<b>DATE:</b>	February 12, 2021	<b>RWDI REFERENCE #:</b> 1904405
<b>TO:</b>	Anthony Witherdin	Director, Key Sites Assessments - DPIE
<b>FROM:</b>	Kevin Peddie	<b>Email:</b> kevin.peddie@rwdi.com
	Michael Pieterse	michael.pieterse@rwdi.com
<b>RE:</b>	<b>ADG Natural Cross Ventilation- City of Sydney Review Response Waterloo Metro Quarter - Building 2</b>

It is understood that after submission of the planning documents for the Waterloo Metro Quarter development, City of Sydney has provided commentary on the submission, with one item related to the natural cross ventilation design of Building 2 in accordance with the Apartment Design Guide. The comments received are noted below, with commentary in response discussed in this report. This document is as an addendum to the submitted Appendix SS – Natural Cross Ventilation report for the project.

NATURAL CROSS VENTILATION

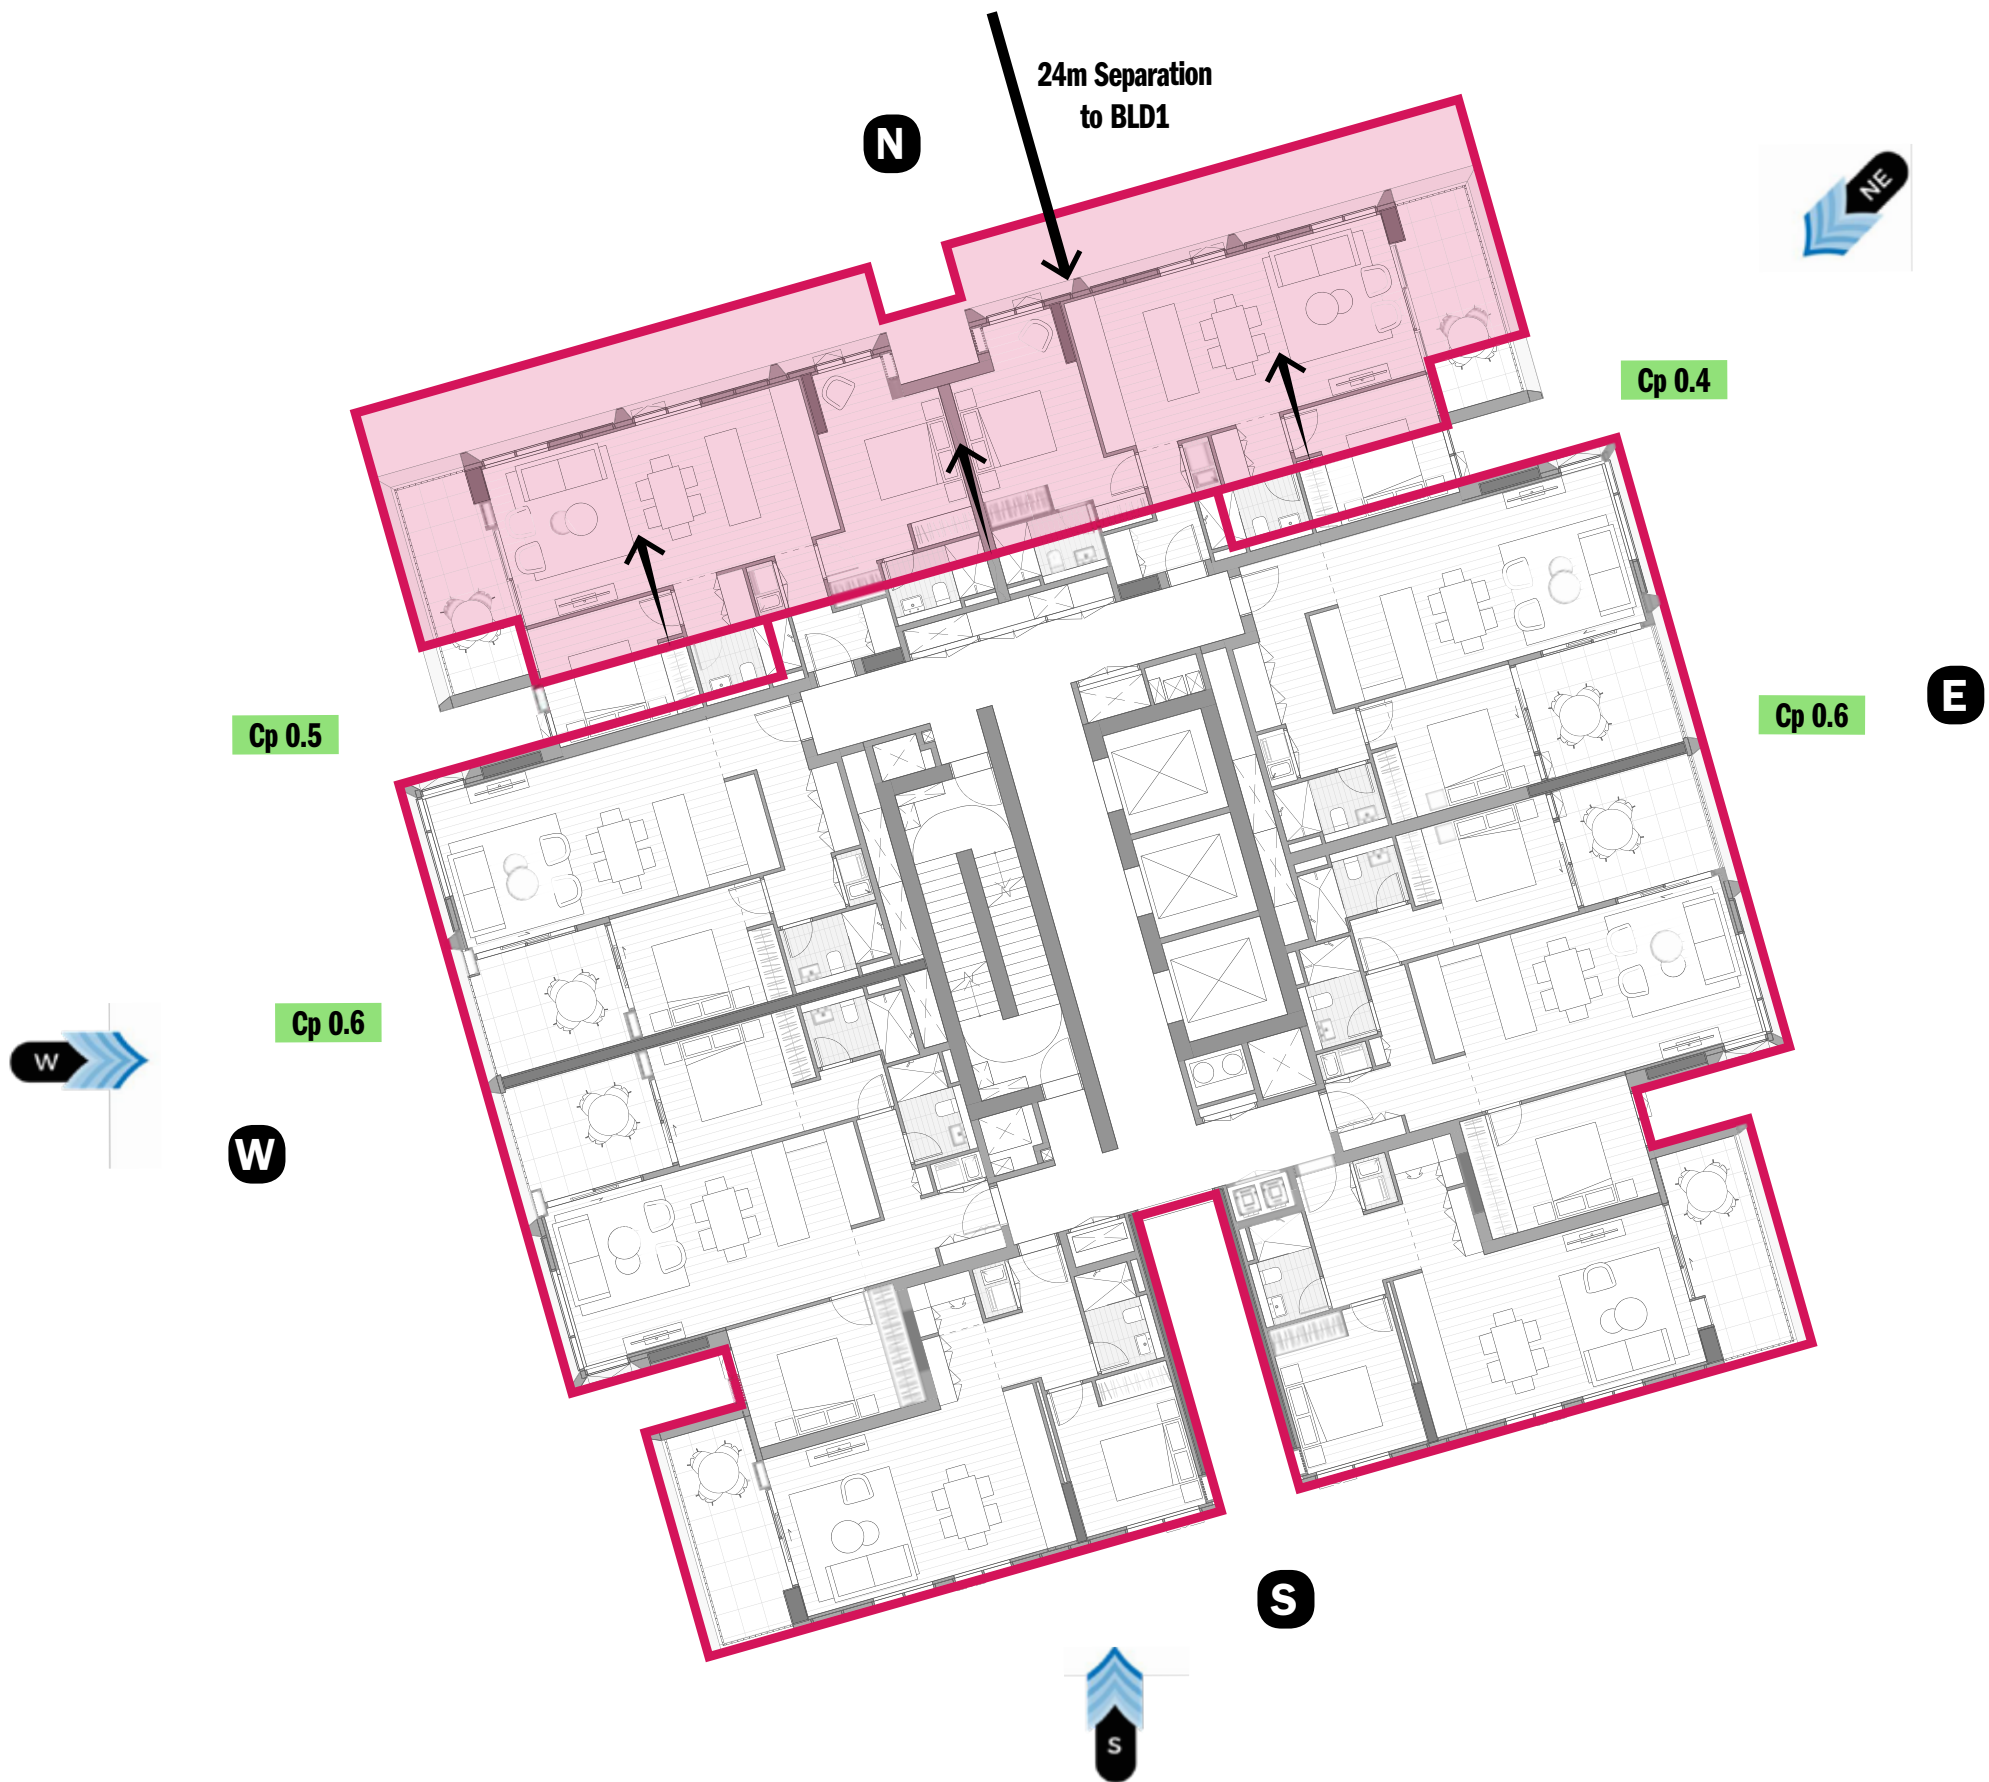
*Natural cross ventilation – Objective 4B-3 of the ADG recommends a minimum 60% of apartments to be naturally cross ventilated. The applicant includes centrally located apartments as achieving natural cross ventilation, notwithstanding these do not meet the definition under the ADG. Furthermore, at least half of the apartments that do meet the definition of natural cross ventilation are noise affected and will require windows and doors to be closed to comply with Objective 4J-1. As such the development provides well below the minimum recommended.*

Figure 4B.8 of the ADG (noted in Image 1a below) indicates *one approach* for how natural cross ventilation can be achieved. The design guidance for this simply notes that “The building should include dual aspect apartments.....”. Dual aspect apartments are noted in the Glossary of the ADG as cross ventilating the apartment which have at least two major external walls facing different directions. These examples and definitions align with the current design of Building 2.

Furthermore, Appendix 4 of the ADG notes Example Schemes for developments which incorporates the requirements of the ADG. Scheme 8 of Appendix 4 (noted in Image 1b below) indicates a similar floor plan design, consisting of 8 apartments per floor, centrally located apartments on two aspects and setback corner apartments. This scheme notes the design qualities as possessing excellent natural ventilation provided for residents of the building.

The floor plate design of Building 2, also shown in Image 1c shows the alignment of the natural cross ventilation design with the ADG example.
